From: Laura Gibbons
Sent: 17 October 2018 13:24
To: Planning.Responses
Cc: Samantha Allen
Subject: RE: Planning Consultation on: BN/29/18/DOC

Engineers Comments Regarding Conditions 3, 4 and 5

APPLICATION NO: **BN/29/18/DOC**

Site Address: Land to the north of The Flint Barn Yapton Road Barnham
PO22 0AZ

Drawing:
Drainage Strategy

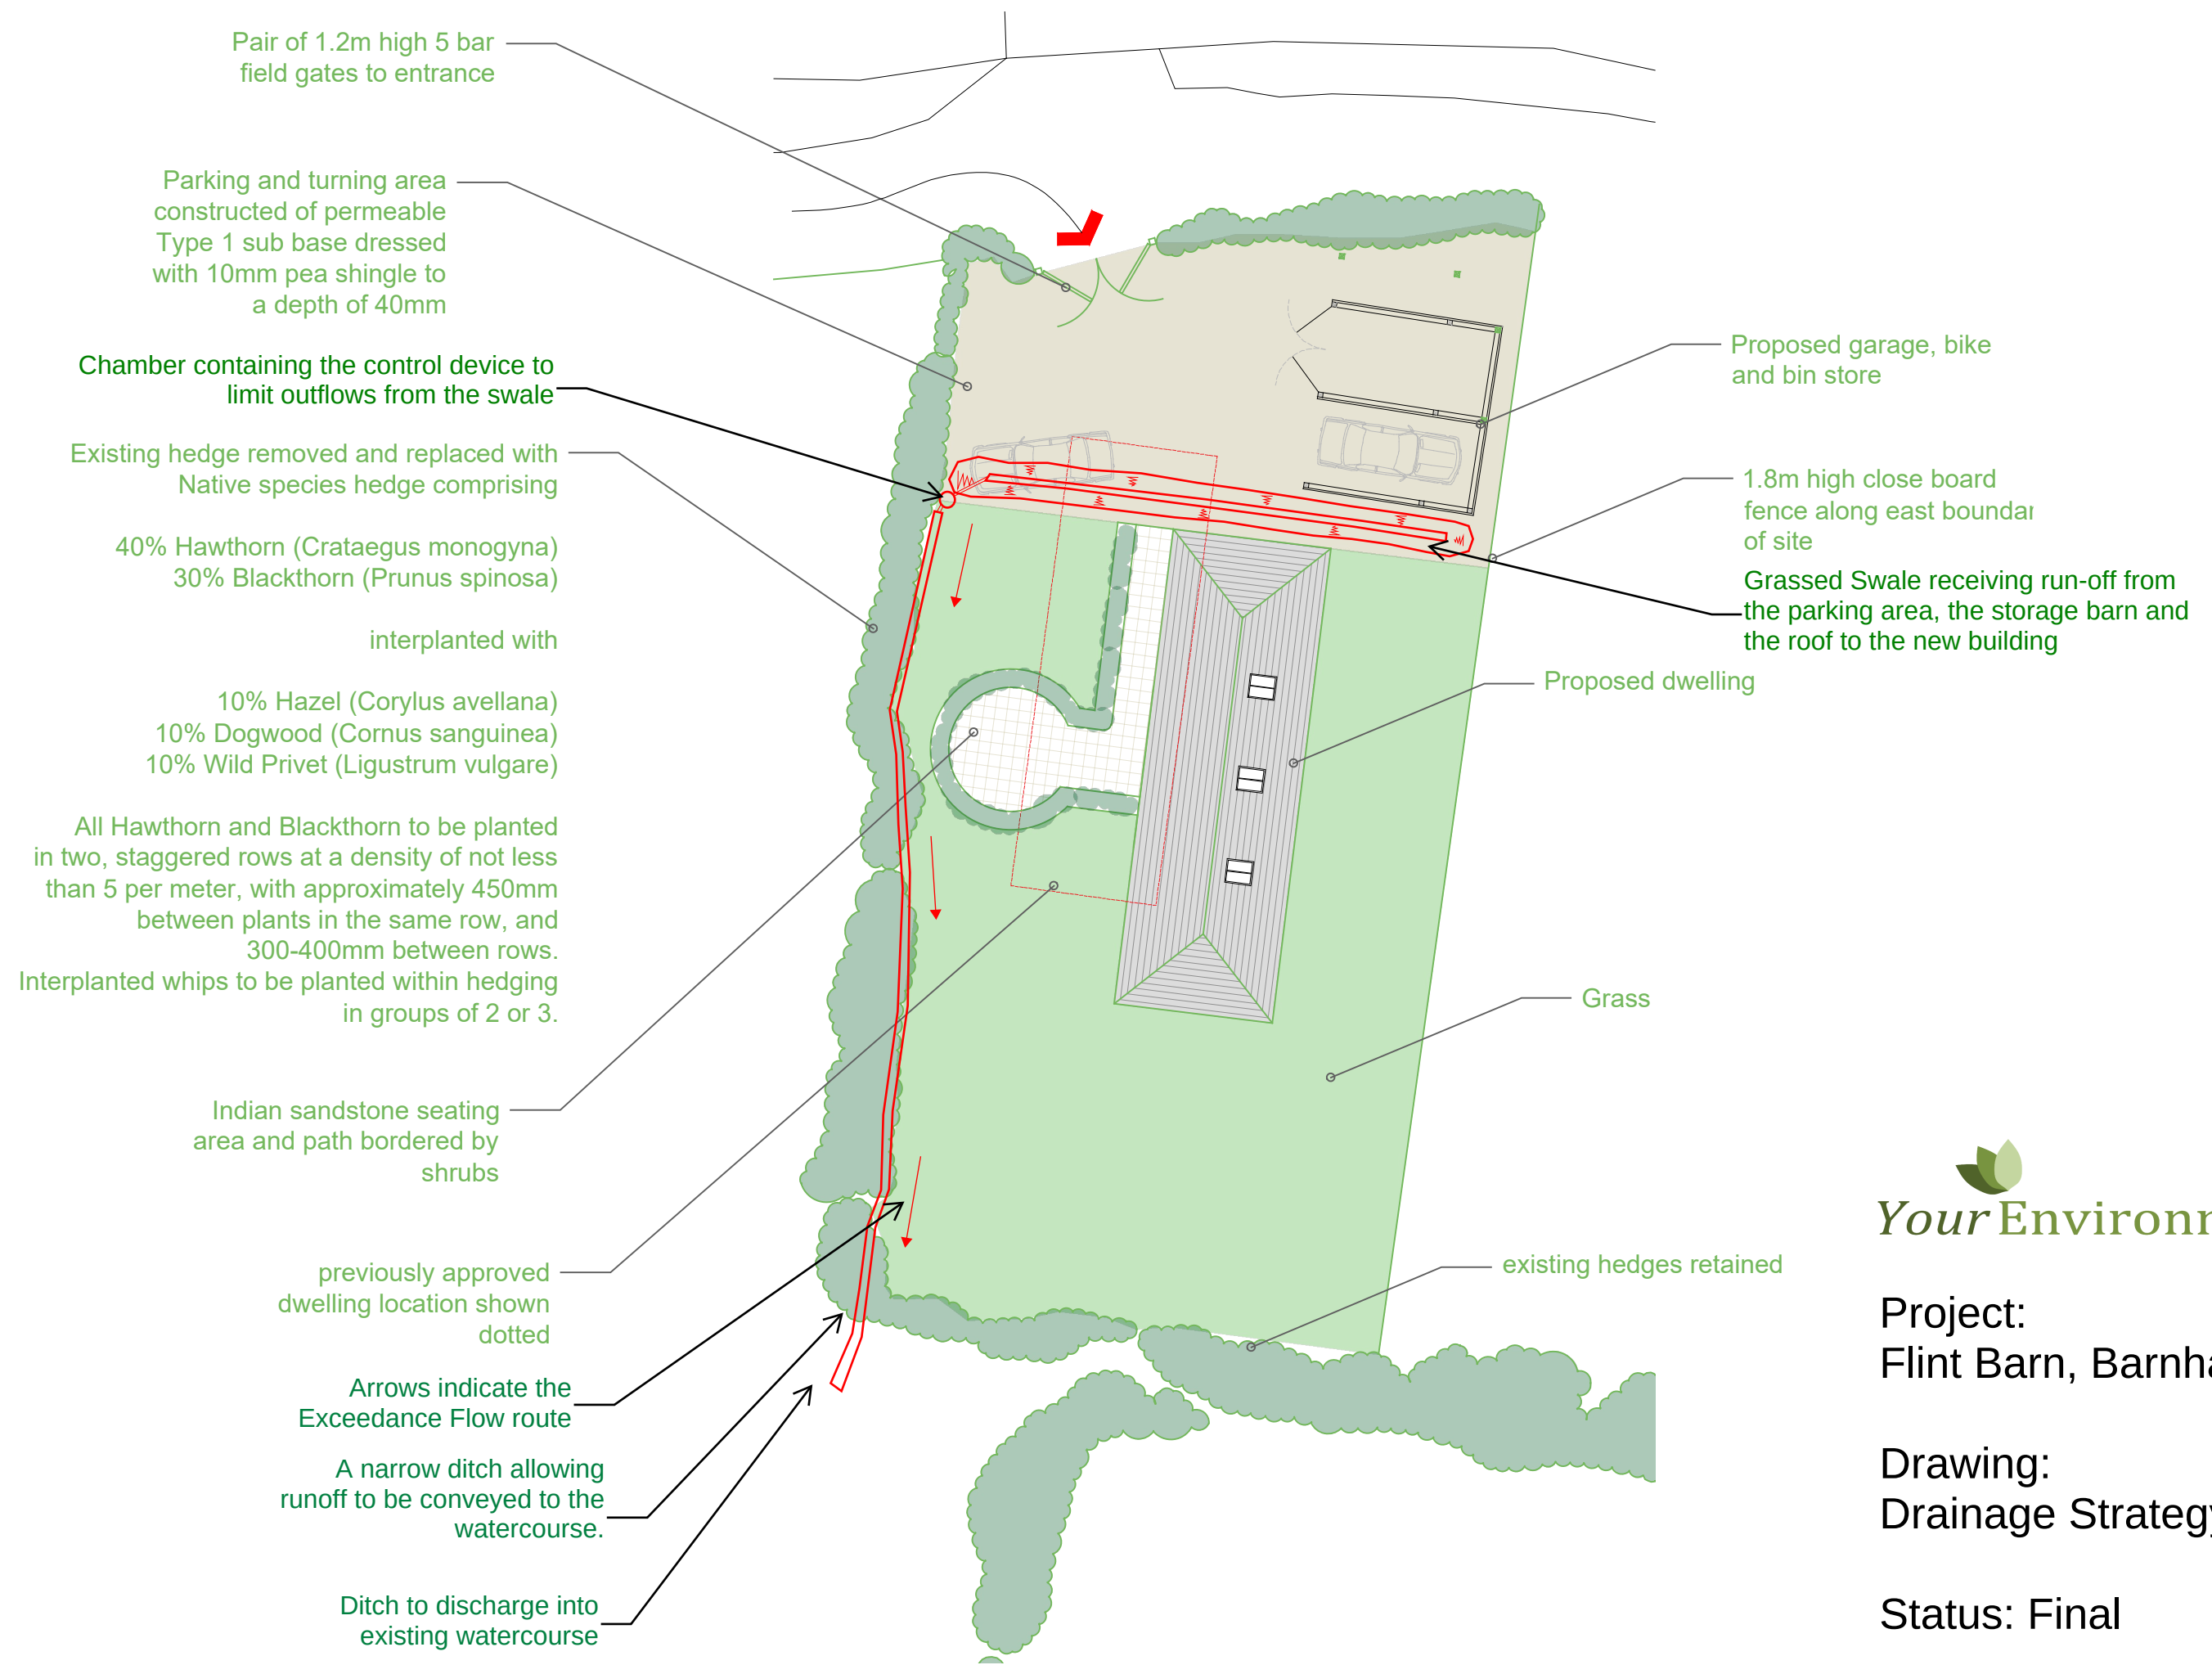
The applicant proposes to form a new swale and connect this into an existing ditch which runs to the south of the site. Winter groundwater monitoring was completed in March, which found ground water levels to be high. We believe groundwater would have peaked before March, therefore may be higher than those levels recorded and we agree with the conclusion that infiltration is unlikely to be viable. However, the applicant may wish to investigate shallow permeable paving solutions.

The proposals currently include for the storage of the 1 in 30 year rainfall event on site. Please revise the plans to accommodate the 1 in 100 year plus 40% climate change event on site. Please also clarify the rate of discharge proposed, orifice diameters have only been provided.

In order to discharge flows to an ordinary watercourse the applicant will need to obtain Ordinary Watercourse Land Drainage Consent, the consent forms for this are attached. I have inspected the watercourse which the applicant proposes on discharging into, it is heavily overgrown. The condition of this watercourse will need to be improved to ensure that flow can be conveyed downstream. The watercourse is culverted and runs under Yapton Road, the condition of this may also need to be reviewed.
